From: [REDACTED]
To: [East Pye Solar](#)
Subject: Incorrect mapping of properties in Baxter's lane (Site 8)
Date: 16 September 2026 13:26:26
Attachments: [Scanned Document 16-09-2026 at 12.44.42.pdf](#)

As requested by staff at OFH2 at Dunston Hall this morning, I attach amended map of your recent Unaccompanied Site Inspection of Site 8, which show omissions of 4 properties in Baxter's Lane which will be impacted by EPS APPLICATION for arrays of Solar Panels, internal haul roads, and CRC 13.

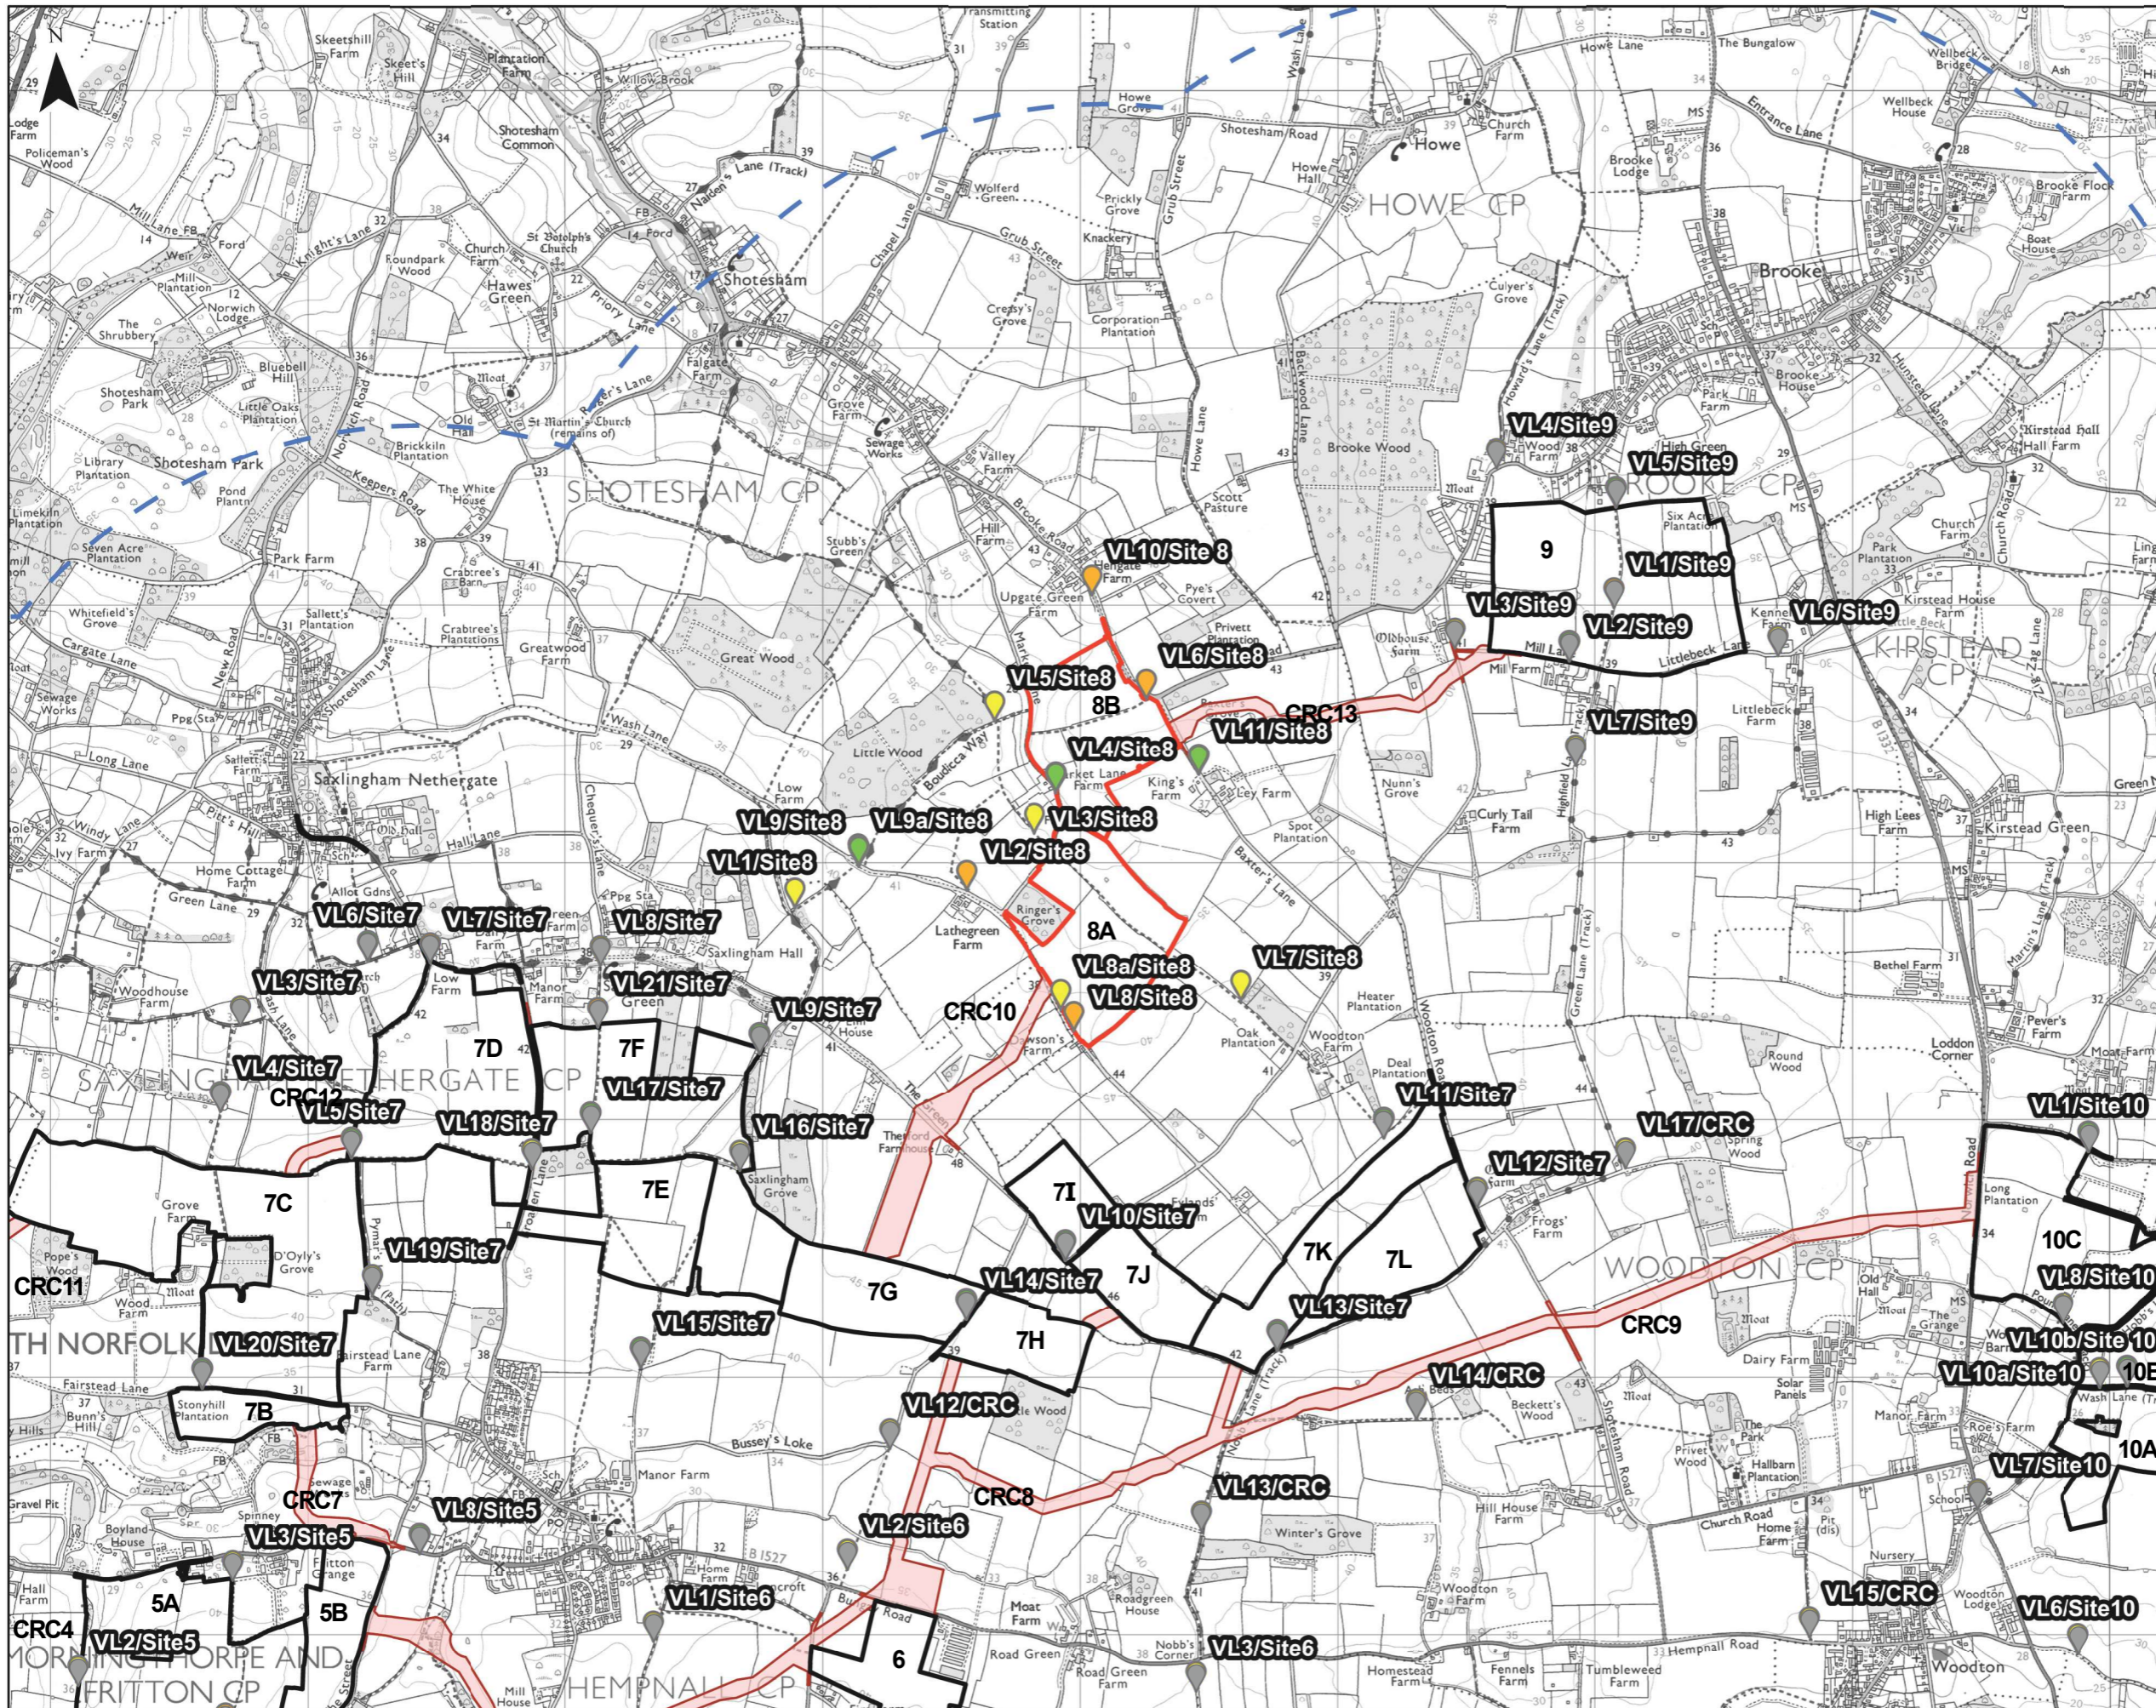
In particular, I draw attention to 'Golden Owl Barn' which sit directly behind 'Kings Farm' which is directly affected both by Site 8b and views across the valley to Site 8a.

'Hill View Barn' 'The Copse' and 'Wodehouse' are located adjacent to 'Ley Farm' and again do not appear on maps used by the applicant but which will be affected by use of Single track Baxter's Lane by crossing CRC 13 and haul road from Site 9 across to site 8b and access to site 8a. During construction and loss of hedges, trees etc.,

Obviously there is concern of contamination to these supplies, and it is very unsettling that EPS have not correctly identified either on maps or visual montages the existence of these properties.
